**Application Number:** 2012-432      **Application Date:** 2/22/2012 12:00:00 AM  
**CBL:** 357-A-1  
**Project Name:** Riverside Golf Course Pro Shop  
**Address:** 1158 Riverside Street

**Project Description:** Construction of Pro Shop Building  
**Zoning:** Recreation/Open Space  
**Other Reviews Required:**  
**Review Type:** Level II Site Plan

November 26<sup>th</sup>, 2012

Project Name: **Riverside Golf Course Pro Shop**  
Project ID: #2012-432  
Address: 1158 Riverside Street CBL: 357-A-1  
Applicant: Portland Department of Public Services  
Planner: Jean Fraser

SHEET #
C003
PLAN NUMBER

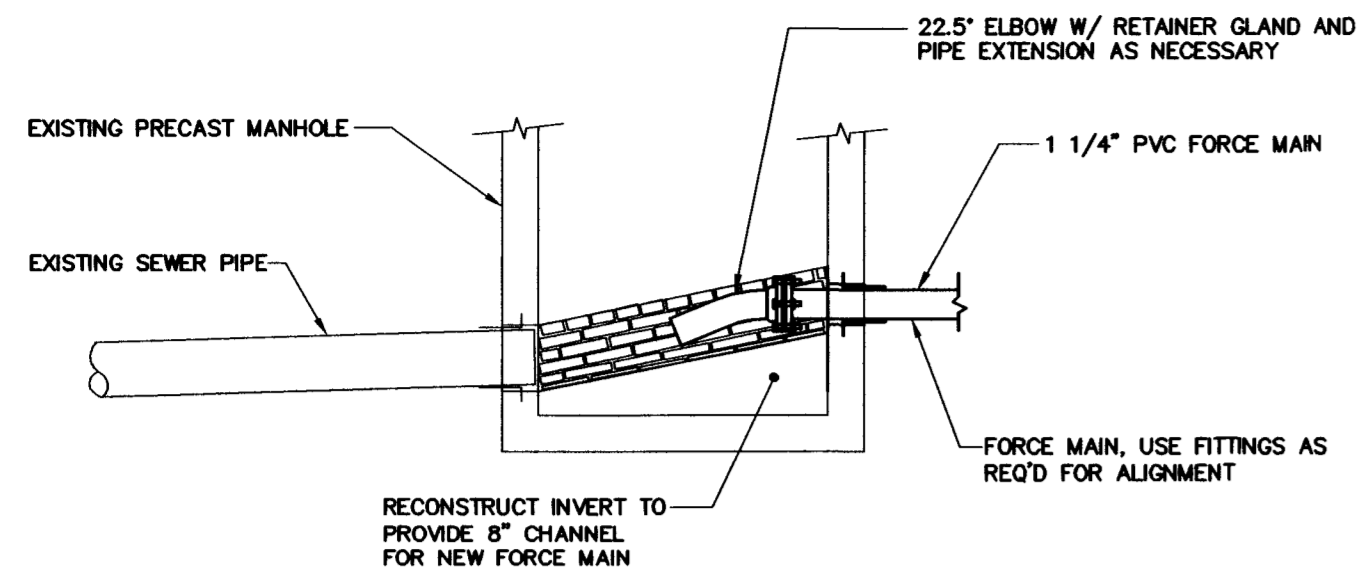
The Planning Authority waives the Technical Standard, Section 1.14 to allow the parking aisle to be 42 feet wide to accommodate golf cart access to vehicles.

1. That the applicant shall submit a detailed Landscape Plan for review and approval by the City Arborist and Planning Authority prior to the issuance of a building permit. The Landscape Plan shall incorporate additional planting to meet the Site Plan standards for parking lot landscaping and shall show all existing trees to be protected during construction and retained, and all new planting (showing location, size and species); and

2. That the applicant shall include in the Landscape Plan (see Condition #1) the design for an enclosure of the condenser on the Riverside Street side of the proposed building, and also show the location and screening of any exterior waste receptacles; and

3. That the applicant shall include in the Landscape Plan (see Condition #1) a full cut off type light fixture on the utility pole on the property line (or on any relocated sign or similar support in the vicinity) near the 5 foot wide walkway where it meets the sidewalk/parking near Riverside Street, to illuminate the pedestrian access walkway and nearby parking spaces; and

3. *The parking aisle width is significant and does not meet City standards. The applicant should document why the City's standards can't be met and formally request a waiver.*

6. *The plan illustrates two marked areas near the two parallel parking spaces. I would suggest that these be raised or of similar material to that being proposed around the building.*

width for perpendicular parking should be 24 feet wide. The proposed parking isle shown on the Pavement Marking Plan is about 42 feet wide in much of the parking area.

In this situation, the parking lot already exists. We are proposing an isle width of 42 feet because that matches the existing conditions and we believe that using the existing parking area "as is" represents the best value for the City regarding golf course operations. Because of budget constraints, we want to avoid spending additional funds to remove part of the existing parking area and narrow the drive aisle width. The existing parking area is in good shape and it is capable of serving its intended purpose for many years to come.

The two marked areas, and the two parallel parking spaces, have been eliminated in the revised plan. Therefore the suggestion that the marked areas should be raised is no longer applicable.

SHEET #
C004
PLAN NUMBER

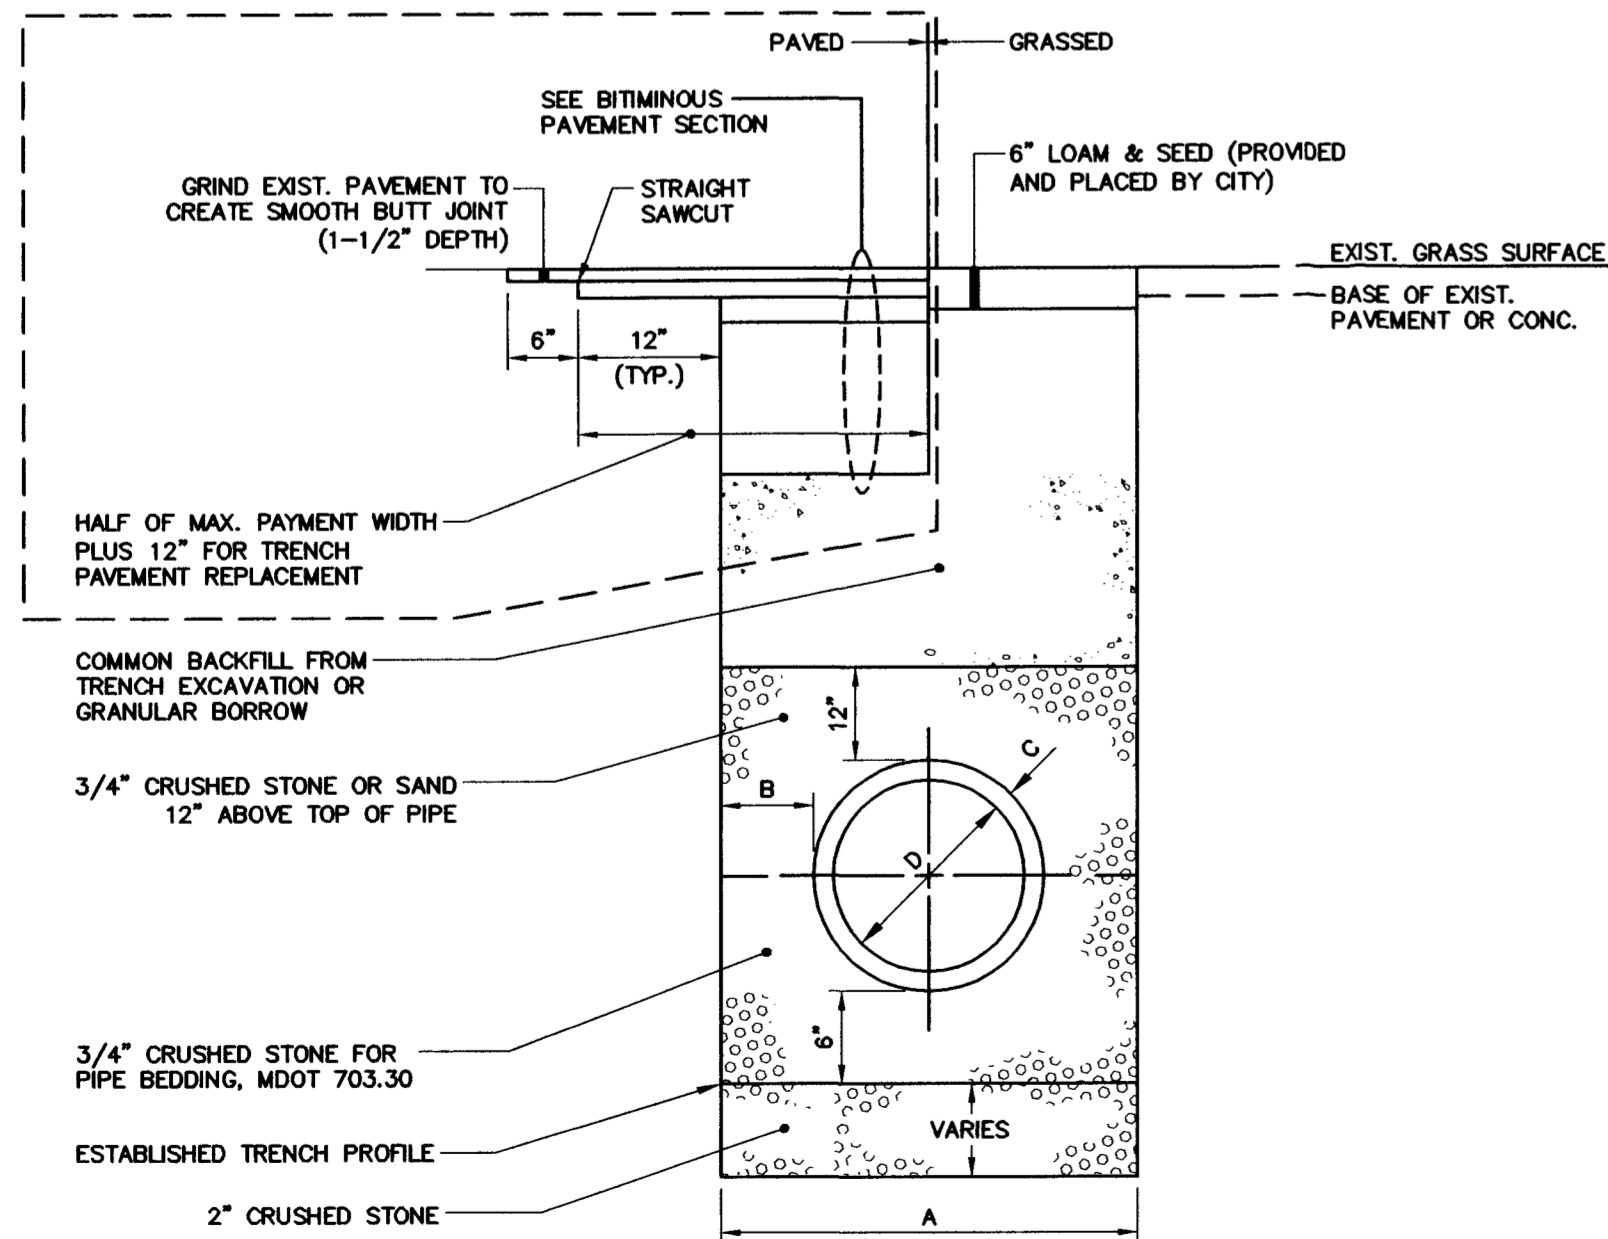
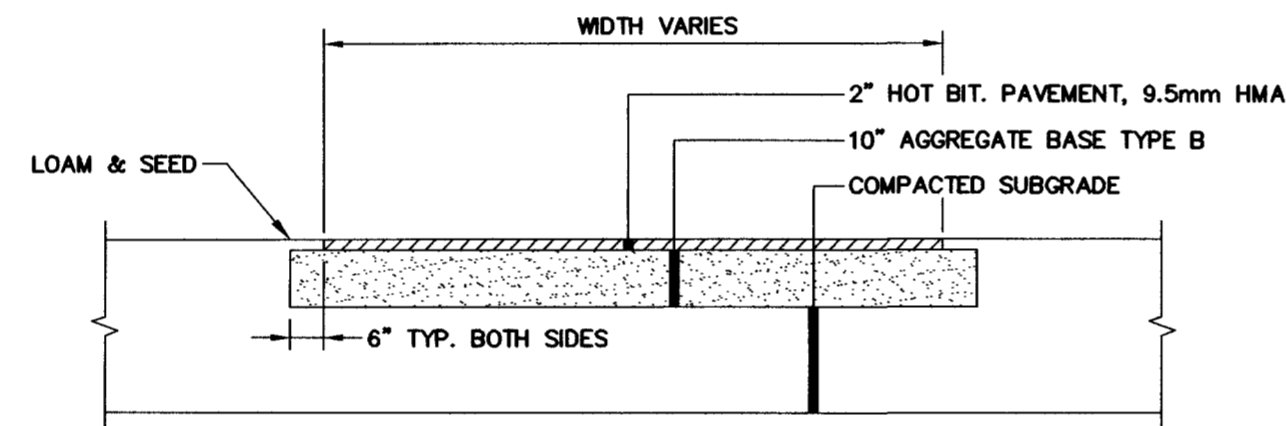
10. *Show detail for approval of reconstructed channel in manhole #1525. Provide a 22 ½ degree bend to force man terminus to direct discharge down 8" sewer out of manhole.*

11. *Please revise Pipe Trench Detail to reflect Portland's Technical Manual Figure II-12.*

To comply with these directives, a detail has been added to sheet C004.

We have complied with this request. The correct detail has added to sheet C004.

DERO 3-UNIT DOWNTOWN BIKE RACK AND CONCRETE PAD DETAIL

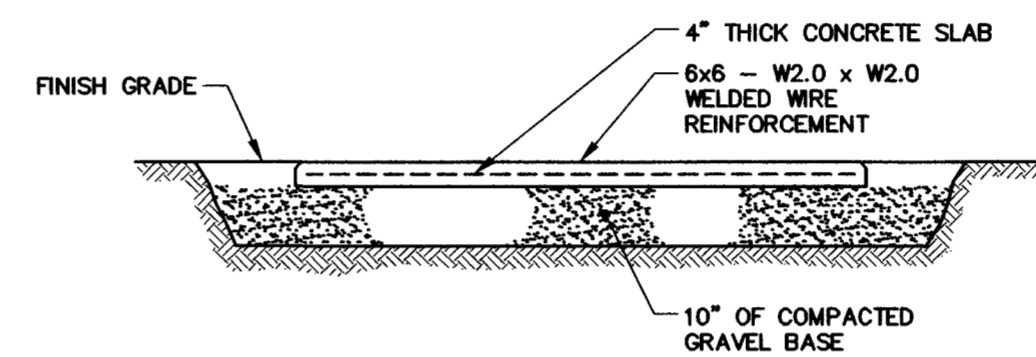
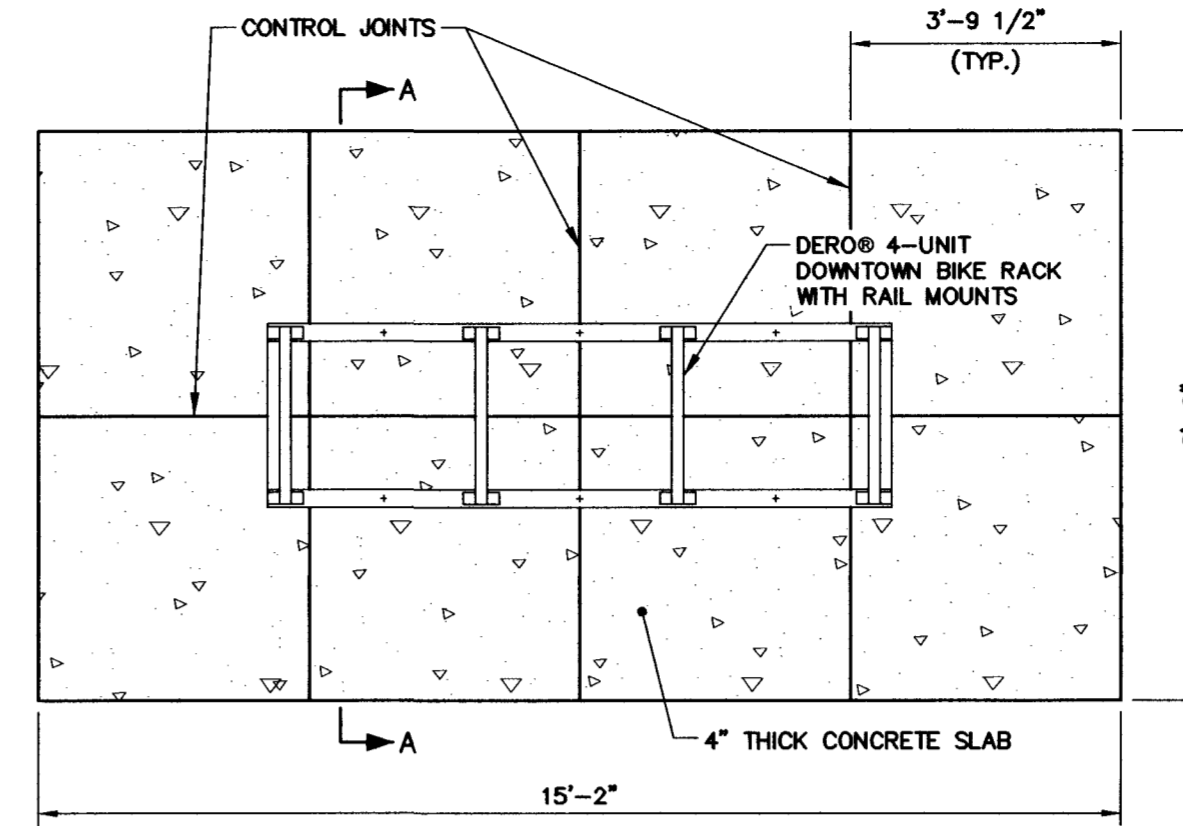
The Planning Authority, in accordance with Ordinance Section 14-526 (a) (4b) 1&2, has reduced the required number of bicycle parking spaces to 8, based on evidence submitted by the applicant that the proposed development is expected to generate reduced demand for bicycle parking.

4. *Bicycle parking space supply should meet City standards (13 to 14 spaces should be provided) [Note: a waiver for 5 of these may be supported ie provision of 8 spaces (4 hitches)].*

The original site plan application includes a proposal to install a rack for up to 6 bikes and a request for a waiver from the regulation that would require 13 or 14 spaces bike parking spaces. If the Planning Authority believes that a larger, 8-bike rack should be installed, and if the Planning Authority would grant a waiver for additional bike rack spaces (in excess of 8 spaces), the applicant would agree to provide a rack with 8 bike spaces. The site plan has been revised to show a bike rack with 8 spaces.

SHEET #
ES100

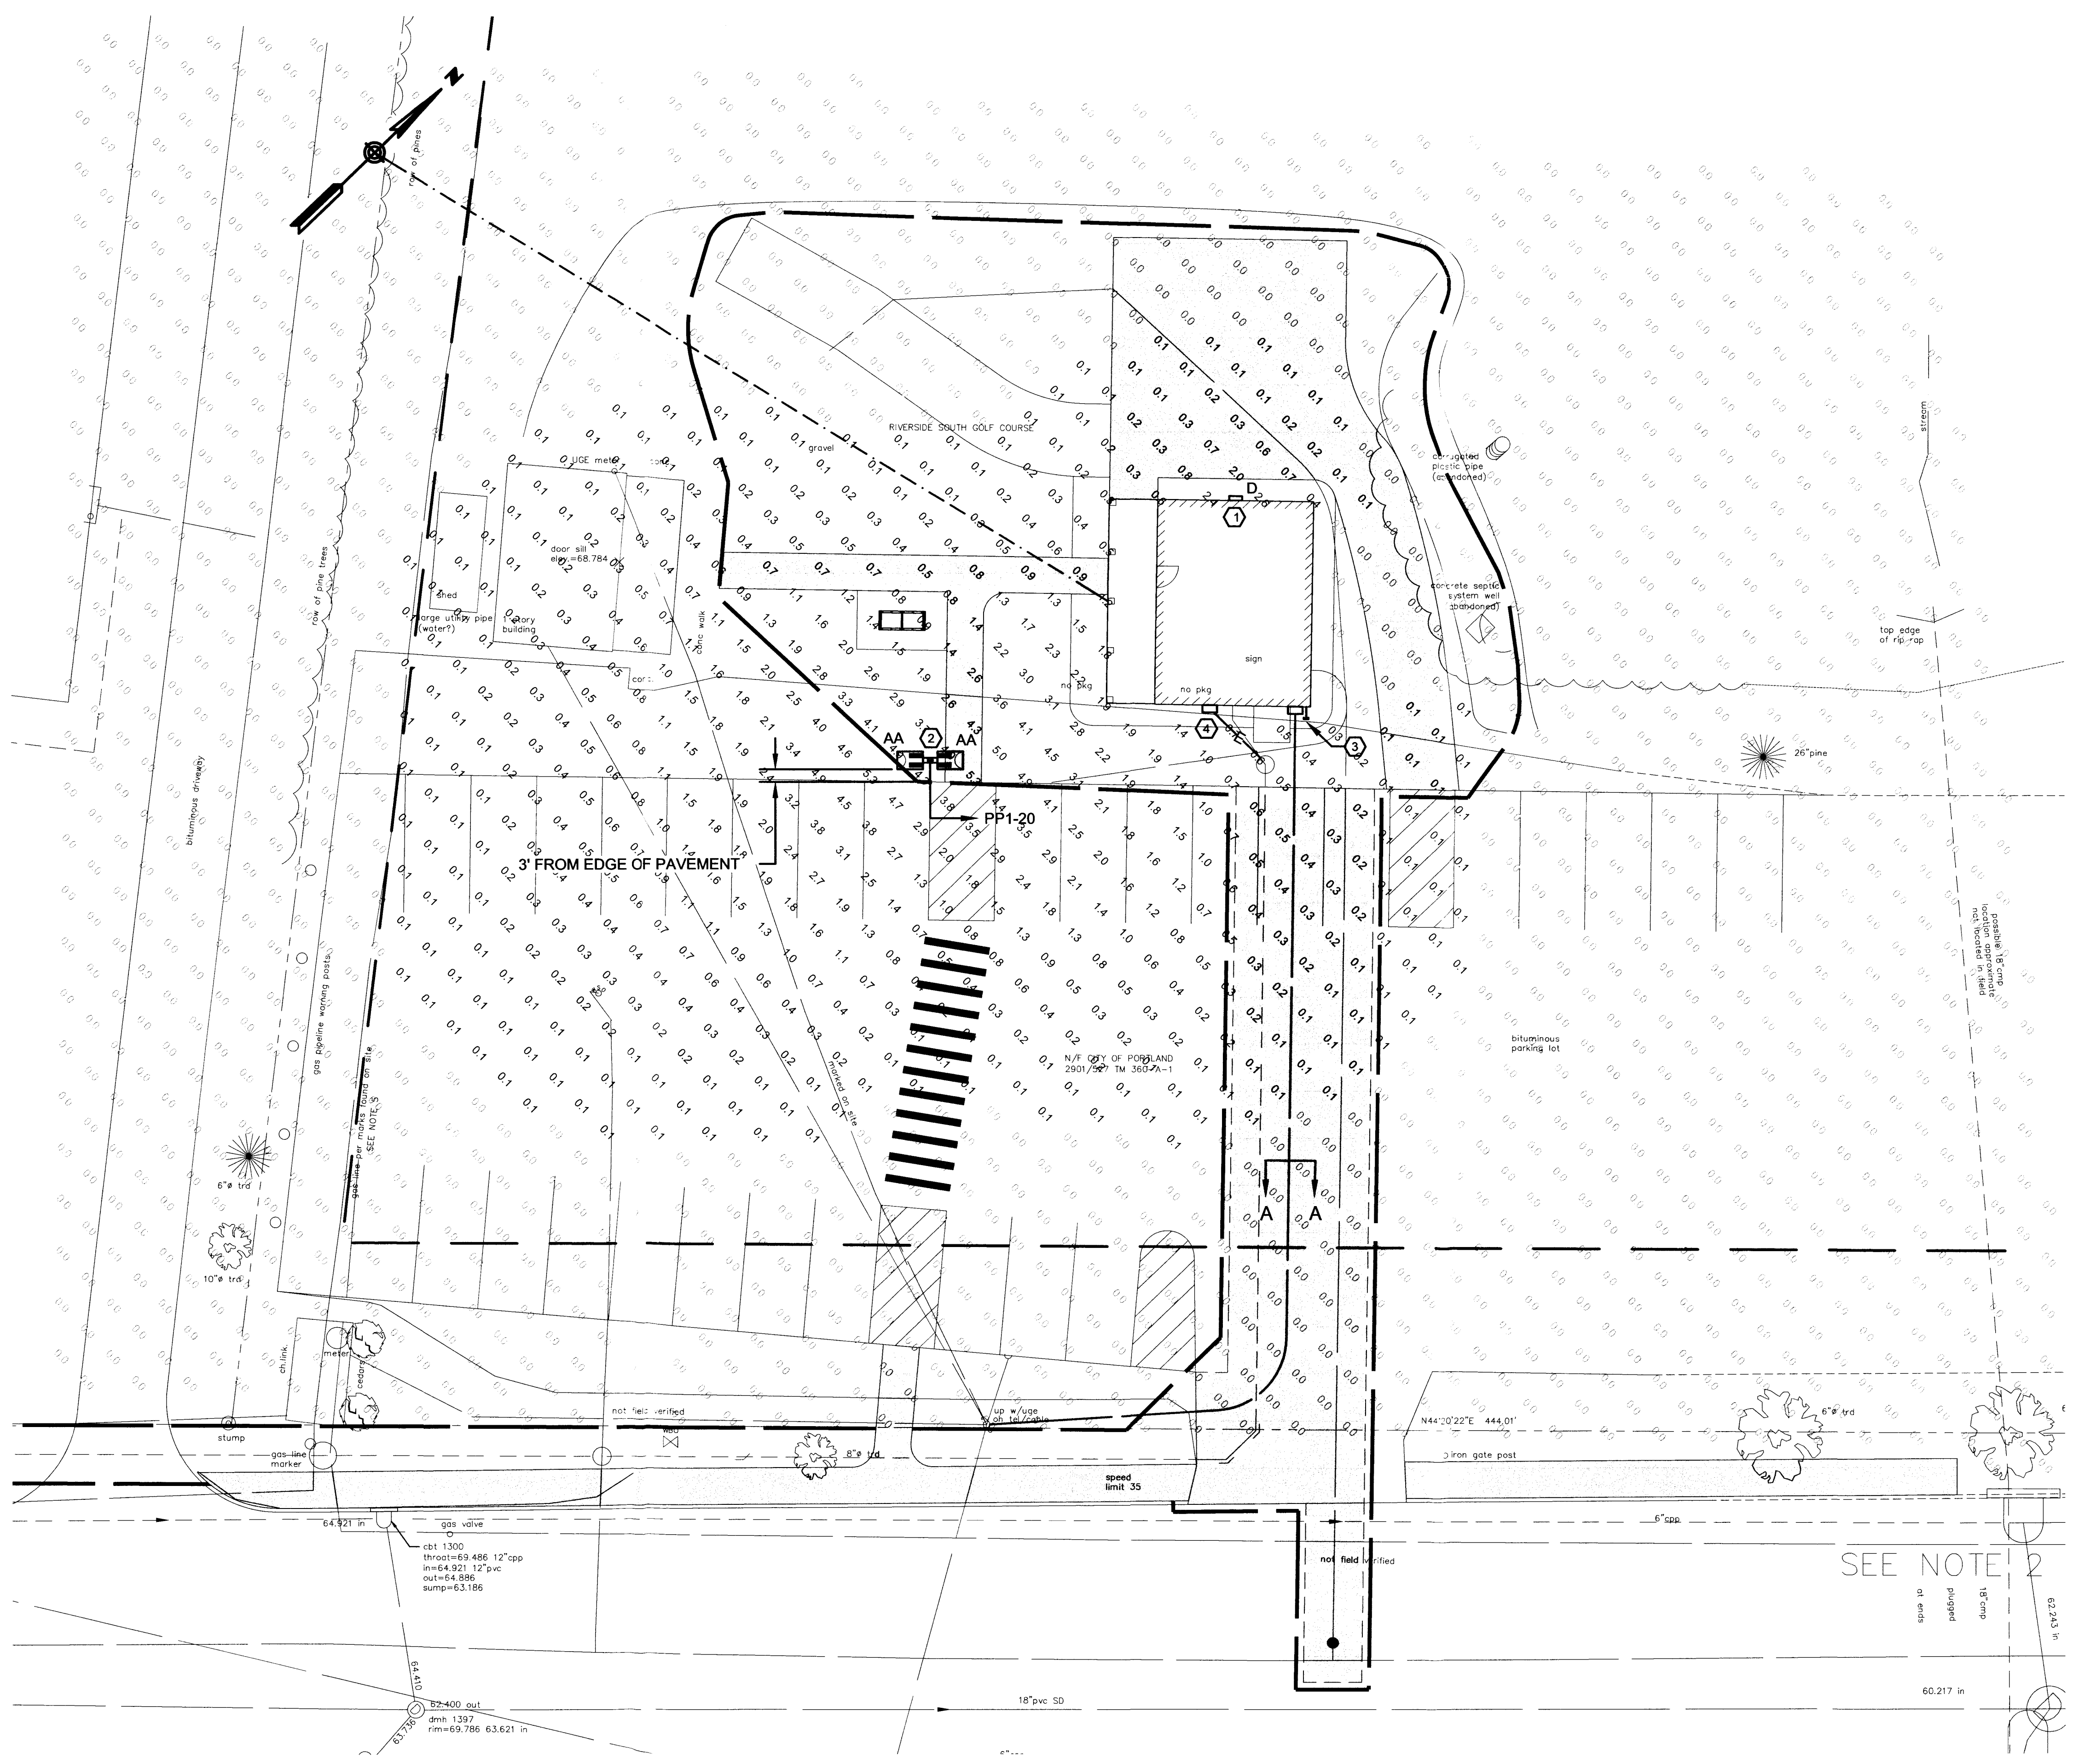
15. *Logic would tell me that this facility would not be used at night but yet there is an existing flood light facing the existing building which is proposed to be retained. Could you give me more info regarding times of use as one of the Site Plan standards is CPTED (see below and also the adopted Technical Standards) and I don't see any narrative on this:*

16. *As you know the existing flood light does not comply with the City Standards and on other projects we have asked for removal of (existing) lights where they are seriously out of compliance. So I need to better understand why that light is there and if it were removed how otherwise (if needed re CPTED and safety) the building/area might be adequately lit.*

DPS proposes to remove the existing pole mounted flood light as part of this project and install three new exterior lights around the proposed Pro Shop. Two of the proposed new lights would be mounted back-to-back on a single pole located adjacent to the parking area and midway between the existing Pro Shop and the new Pro Shop. These two lights would be 20 feet above ground; they would have 78-watt LED fixtures with "cutoff" optics. The third exterior light would be mounted on the northwest side of the building 12 feet above ground. It would be a wall-mounted, 10-watt LED fixture, designed with cutoff optics. A photometric plan showing light intensity levels with these three fixtures is being submitted herewith; please refer to plan sheet ES100.

DPS realizes that the existing flood light does not meet the existing design standards, which require "cutoff" fixtures that do not create light trespass onto neighboring property. For this reason, DPS agrees to remove the existing flood light as part of this project.
